Town & Country Planning (Control of Advertisement) (England) Regulations 2007 (as amended)

3 No. externally illuminated fascia signs, 2 No. non illuminated fascia signs & 2 No. non illuminated panel signs to various elevations (resubmission following AW/215/14/A).

The Ship Inn Aldwick Street Aldwick

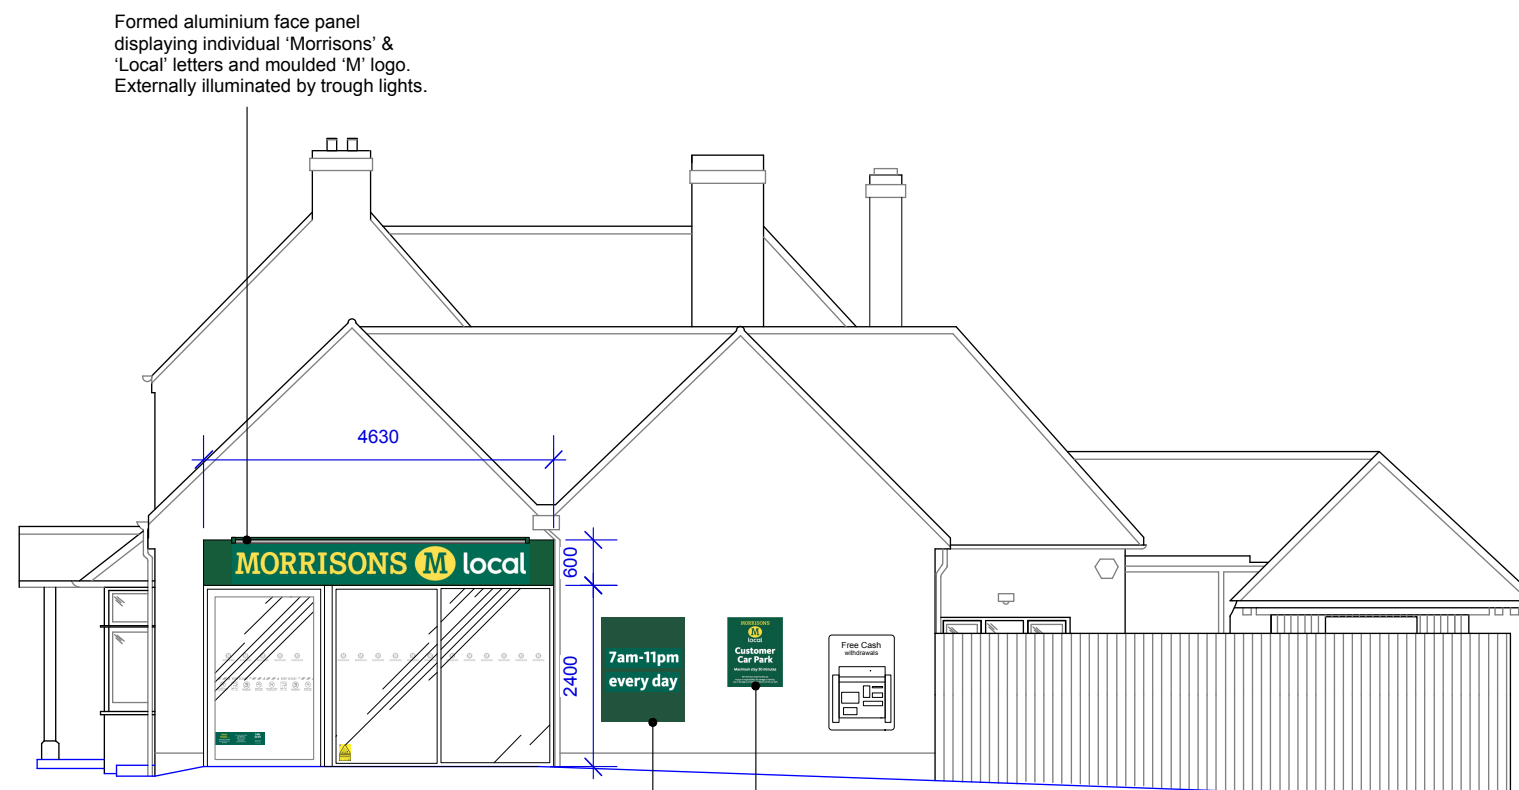
In particular, Sign 1 on w. elevation, is a duplicate of the already agreed hanging sign (Sign 3) and therefore superfluous.

Sign 2 totally unnecessary and any illumination would add to light pollution for residents opposite.

Sign 4 (opening times) is far too large and really not required - this information could be displayed much more discreetly on the door.

Sign 5 over the door is far too large and obtrusive. Whilst it is not unreasonable to have a name over the door it does not need a sign of this size. Also, no need for illumination as this just adds to more light pollution for residents. Presumably the shop lights will be on and in themselves will give out much more light than the previous public house.

DRAWING
PROPOSED SIGNAGE SITE PLAN
PROJECT
**THE SHIP INN
ALDWICK STREET
BOGNOR REGIS PO21 3AP**

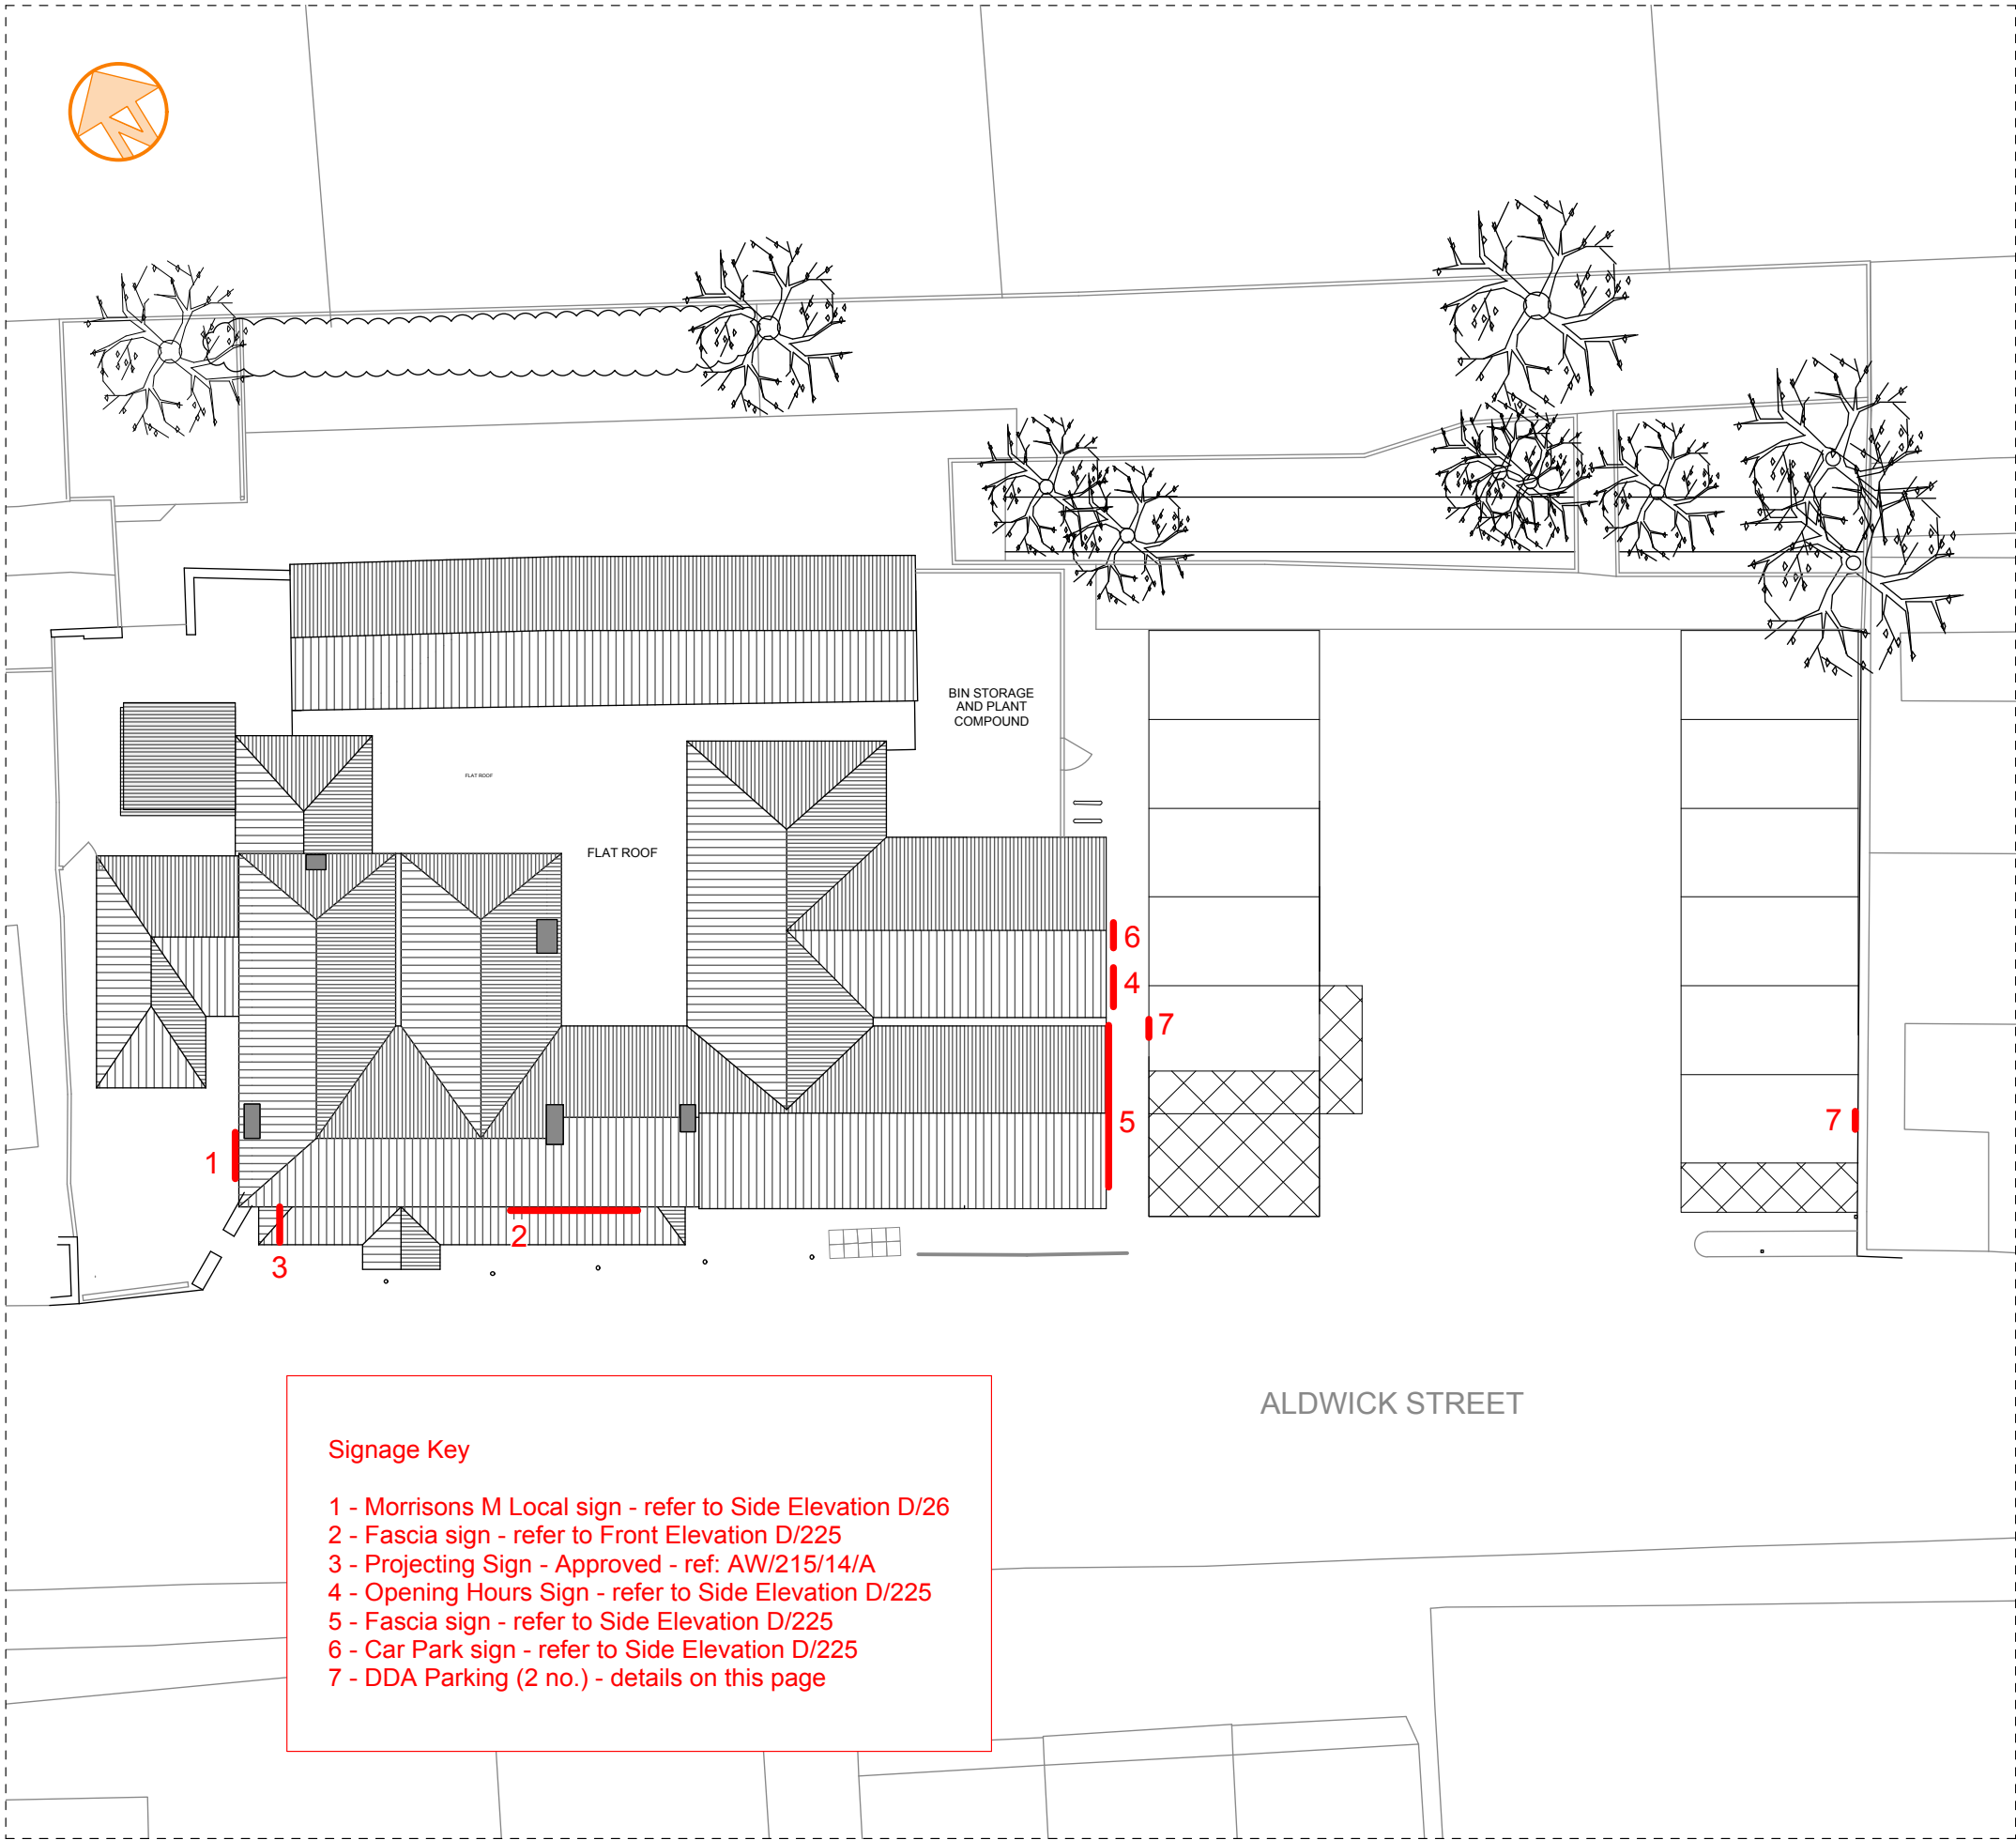
Sign 6 - acceptable as a notice to the public.

Sign 7(x2) - again acceptable for users but a steel post?

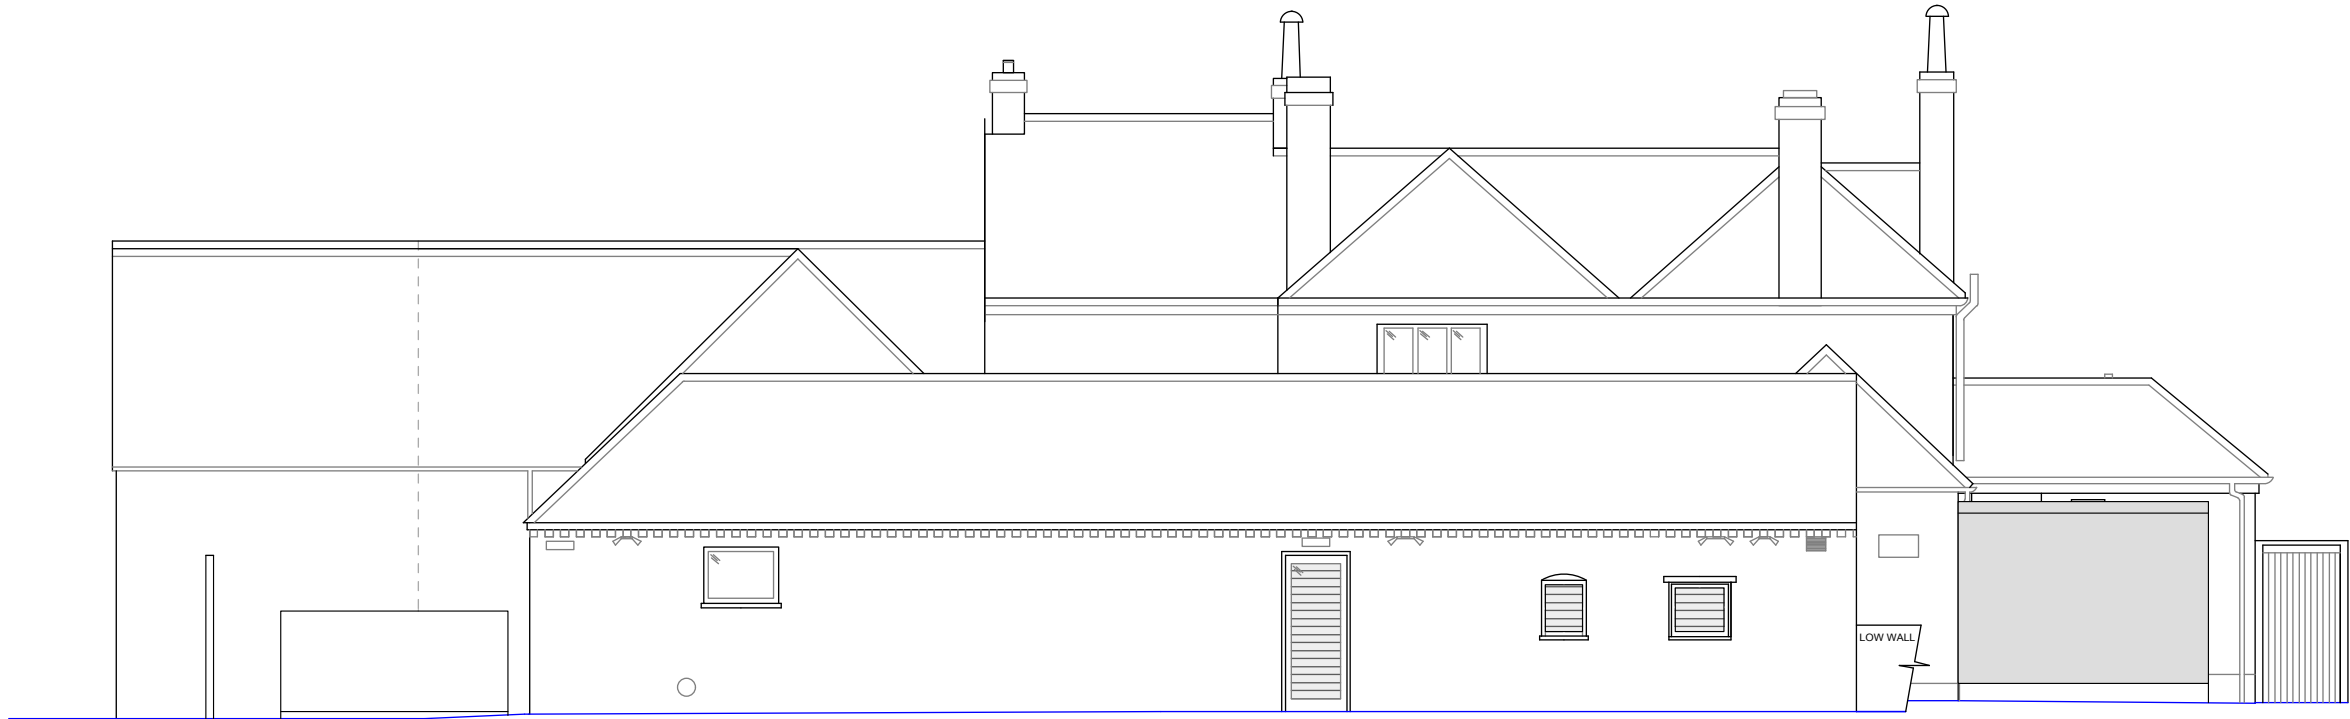
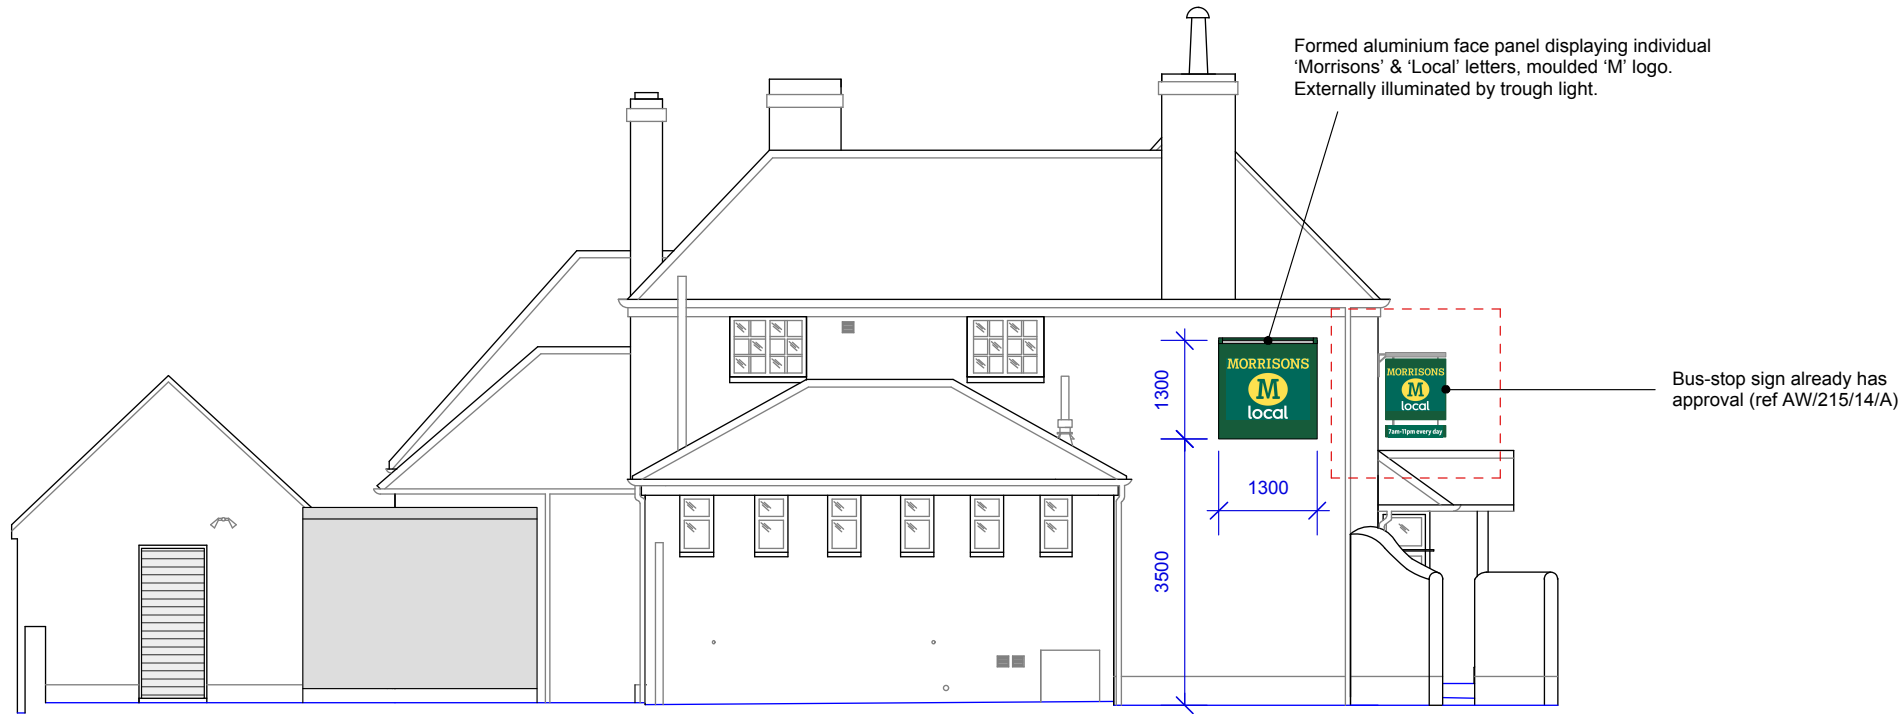
Additionally, it is noted that there are what appears to be electrical cables protruding high on the newly created gables on the eastern elevation, yet there is nothing shown on the plans to indicate these or their use. This should be clarified.
